DECISION DELEGATED TO HEAD OF PLANNING

Application No: H05-0004-25 **Applicant:** Mr & Mrs Banhire
Proposal: Proposed two storey rear extension
Location: Cherry Trees 2 Joys Bank Holbeach St Johns
Terminal Date: 3rd March 2025

CASE OFFICER ASSESSMENT

PROPOSED REAR ELEVATION (SOUTH)
1:100

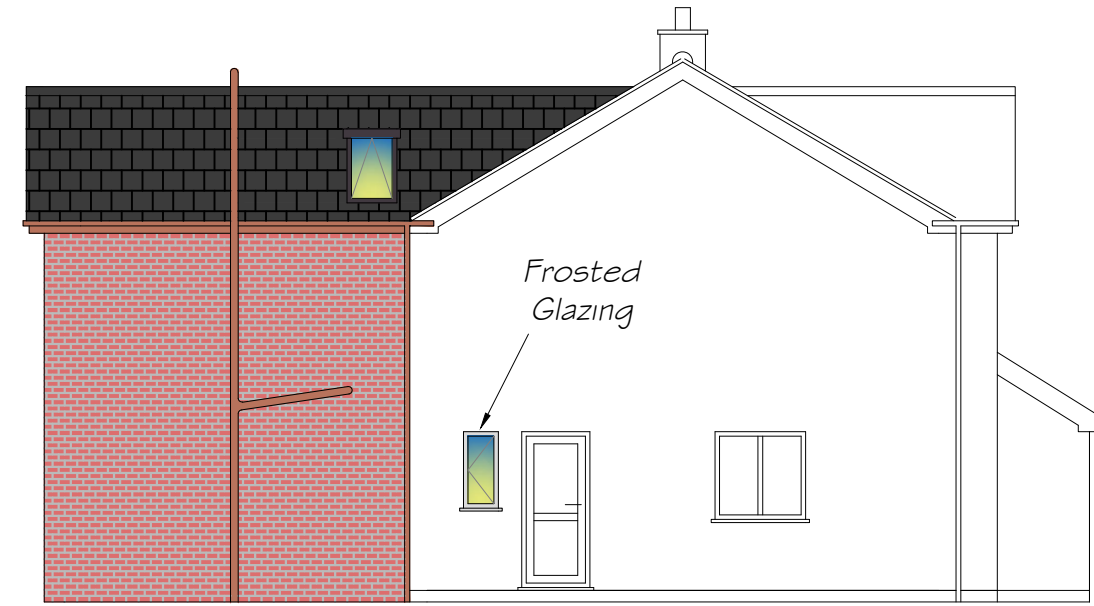
The proposed extension would be located on the south-eastern elevation of the dwelling, and as such the extension would not be particularly visible from the site frontage. The extension would feature two storeys and a gable end roof form. The extension measures 5m by 5.47m. The extension would extend slightly further to the rear than the existing single storey rear extension which will be retained.

The ridgeline of the proposed extension measures 6.8m from the ground, and this is the same height as the ridgeline of the two-storey projection which is on the front of the dwelling. Furthermore, the ridgeline is not taller than the ridgeline of the main dwelling. As such, the scale and siting of the

The proposed materials include multi red textured facing brickwork to match the existing brickwork, Sandtoft Brindle Double Roman Interlocking tiles to match the existing tiles, and brown uPVC to match the existing uPVC. The proposed materials are therefore acceptable as they would match the existing materials, therefore helping to integrate the extension.

The only new windows which are proposed would be located on the eastern side elevation, which faces onto 4 Joys Bank. The proposed windows include one ground floor window which connects to a small bathroom, and one rooflight window. Neither of these windows would cause an adverse impact in terms of overlooking. There is a note on the submitted elevation plans that the bathroom window will feature frosted glazing. A condition is recommended to ensure that an appropriate level of obscure glazing is incorporated.
